CITY OF ALBUQUERQUE

August 10, 2015

**Re: Tract 2A1B Renaissance Center
Erosion Sediment Control Plan
Engineer's Stamp Date 7-31-15 (F16E013A)**

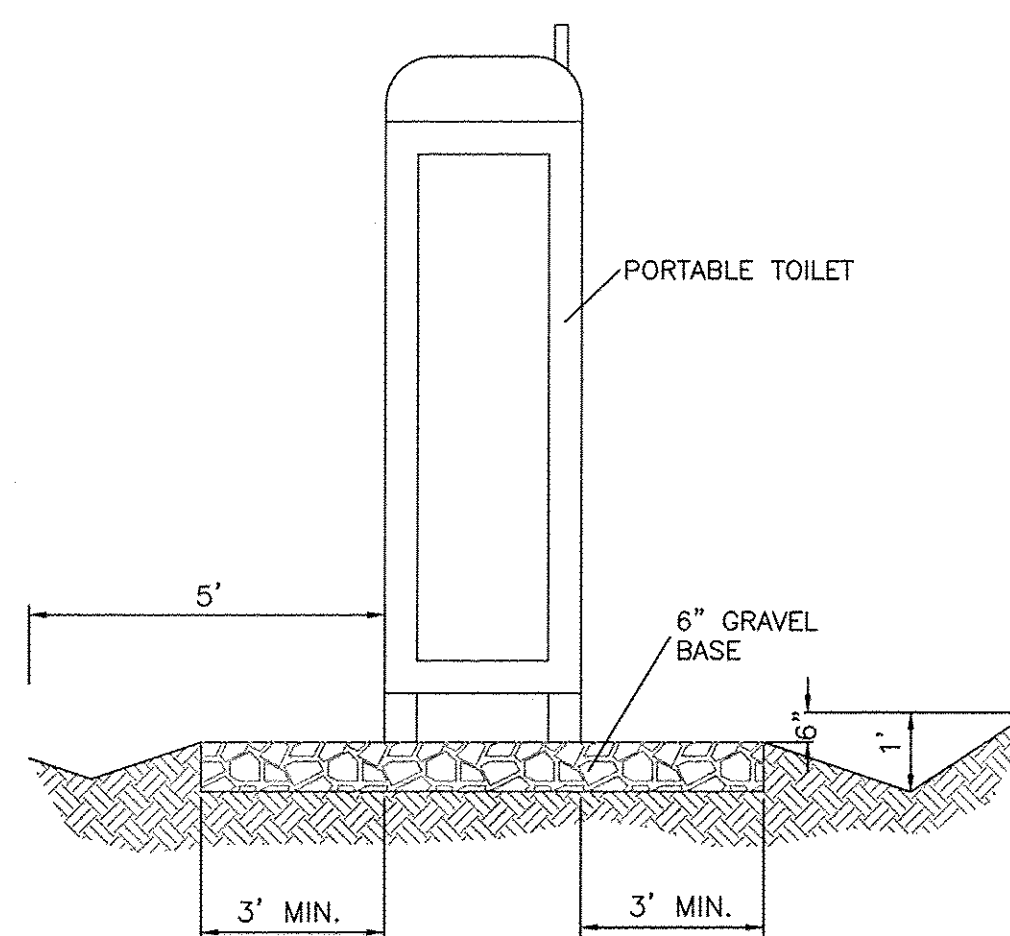
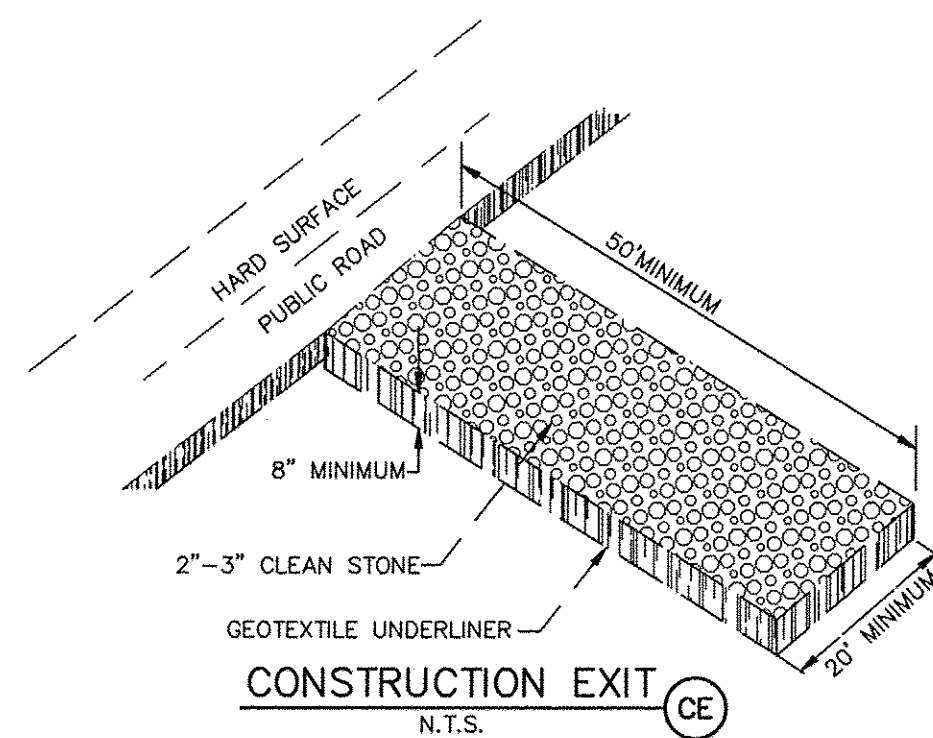
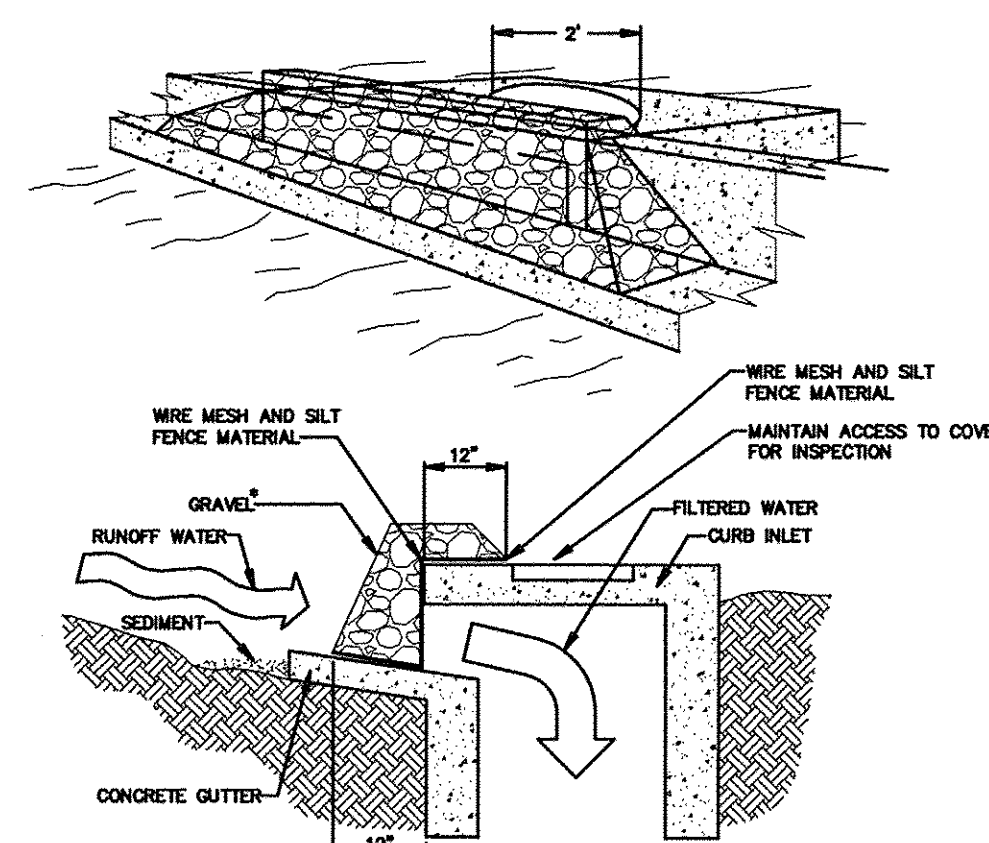
1. For the construction entrance, consider using 3"-6" stone rather than 2"-3" stone. The larger size will create more bounce.
2. A wattle may work better than silt fence for inlet protection as it is more permeable.
